8th May 2020

Our Ref: A18652-L2/af

**RE: LIGHT HORSE INTERCHANGE BUSINESS HUB (SSD 9667)
RESPONSES TO SUBMISSION – DEPARTMENT OF PLANNING, INDUSTRY
AND ENVIRONMENT.**

Figure:
2-5

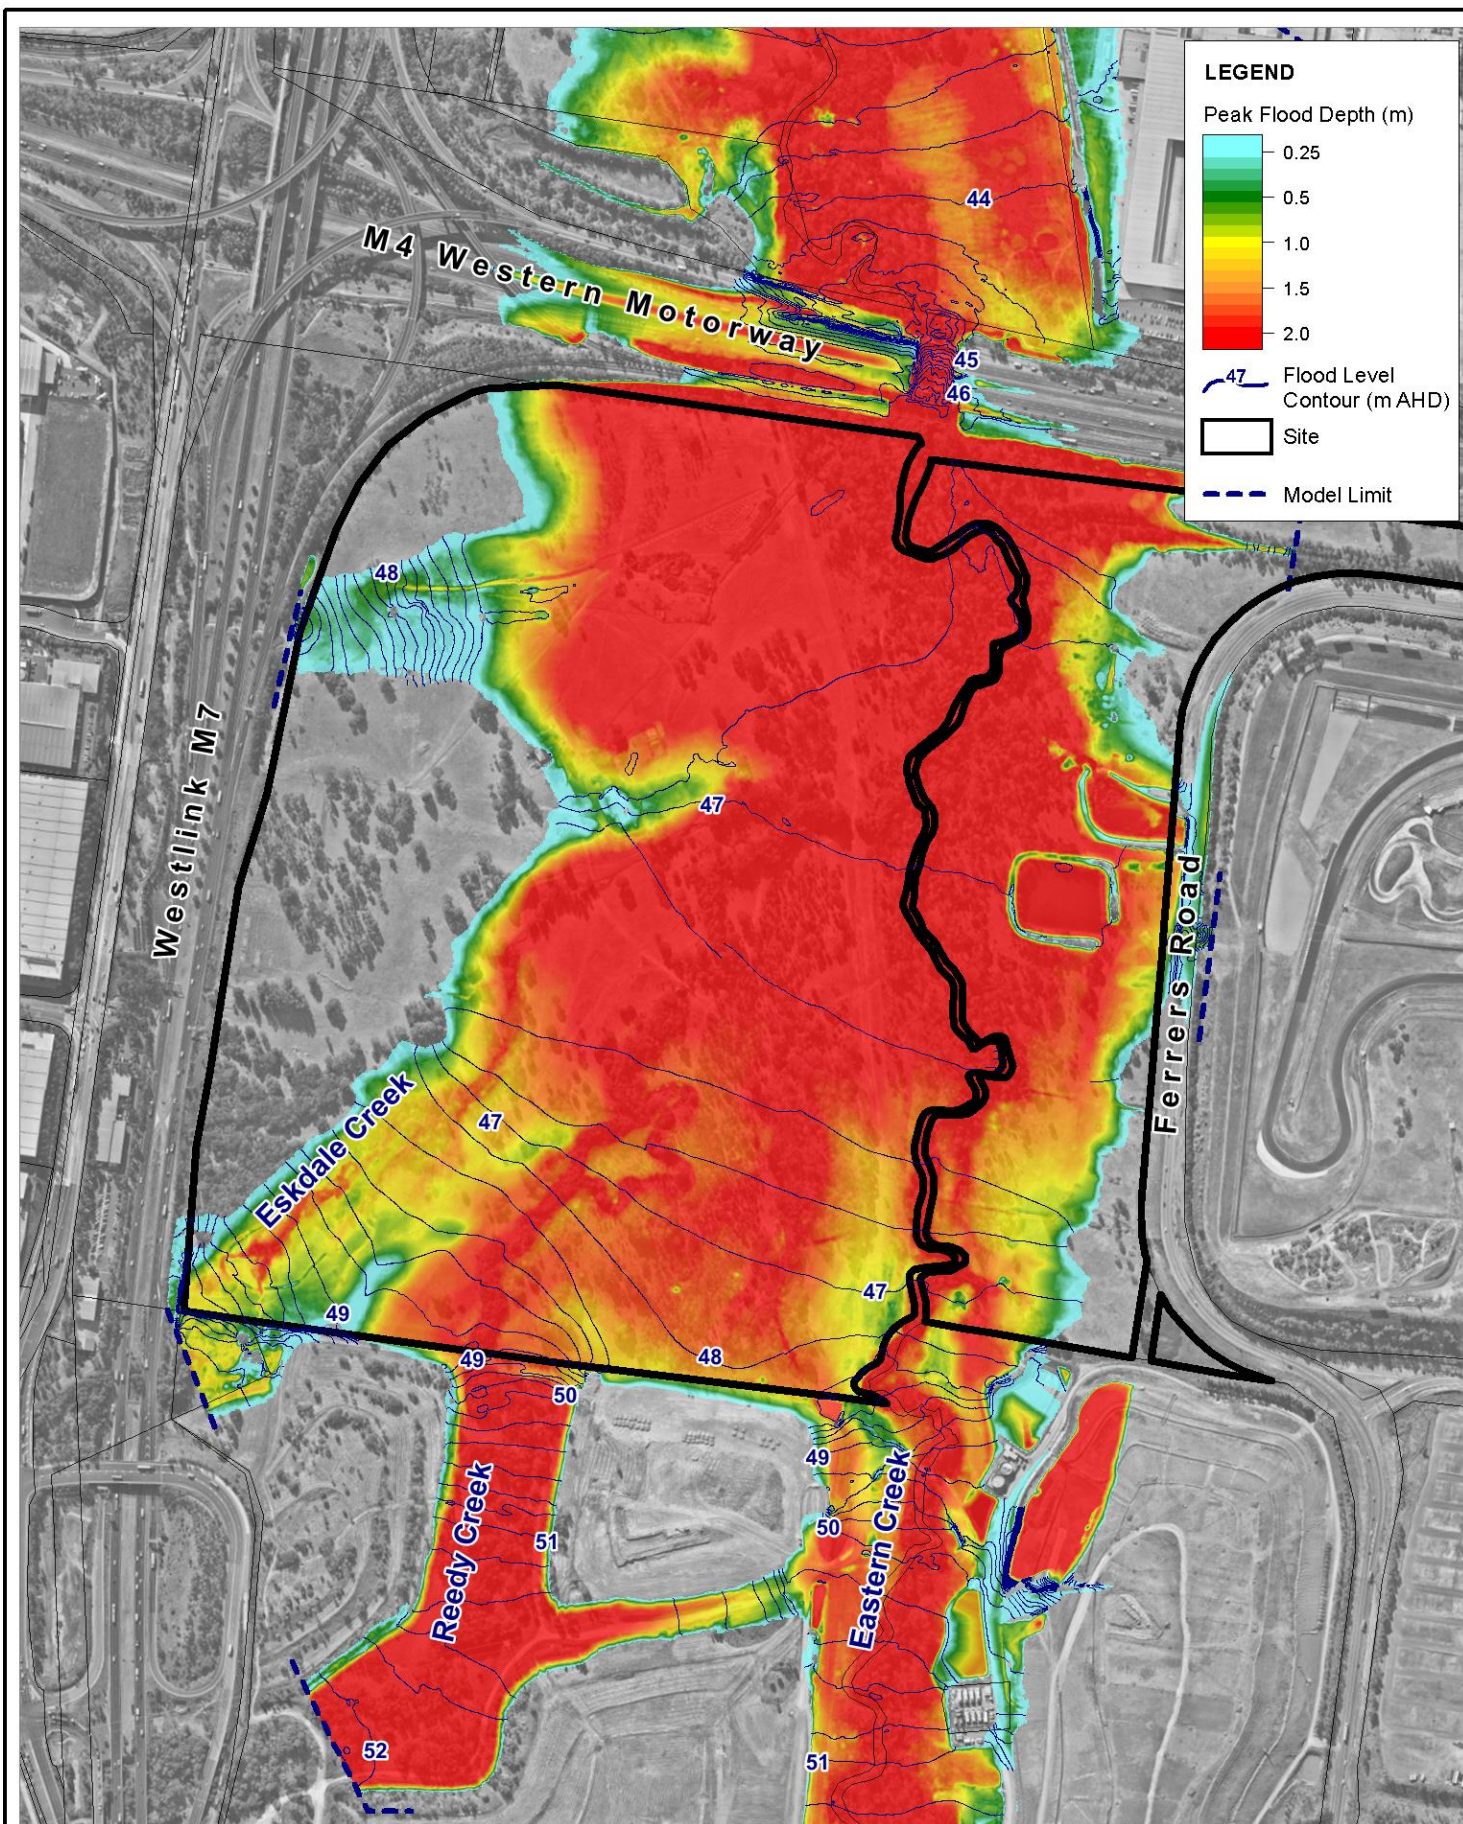
The EIS identifies that approximately 905,000m³ of fill is to be imported (pg. 49). The civil engineering plans show filling of up to 6 m across parts of the site. Further explanation and justification is required for the extent of filling proposed given the difference between the building pad levels and the 1 % AEP flood levels.

As previously established in response to comment 1, it is ideal to provide a single communal water management basin in the currently proposed location. From review of Figures 2-5 & 3-2 of Flood Impact Assessment, it is noted flood levels in both the existing and post developed scenario generally fall in towards the North East. In terms of interaction with flooding, the on-site stormwater detention basin is optimally located within the site at a location with the lowest available flood levels whilst still providing an outlet that discharges to an existing watercourse and does not cross the existing high-pressure gas line.
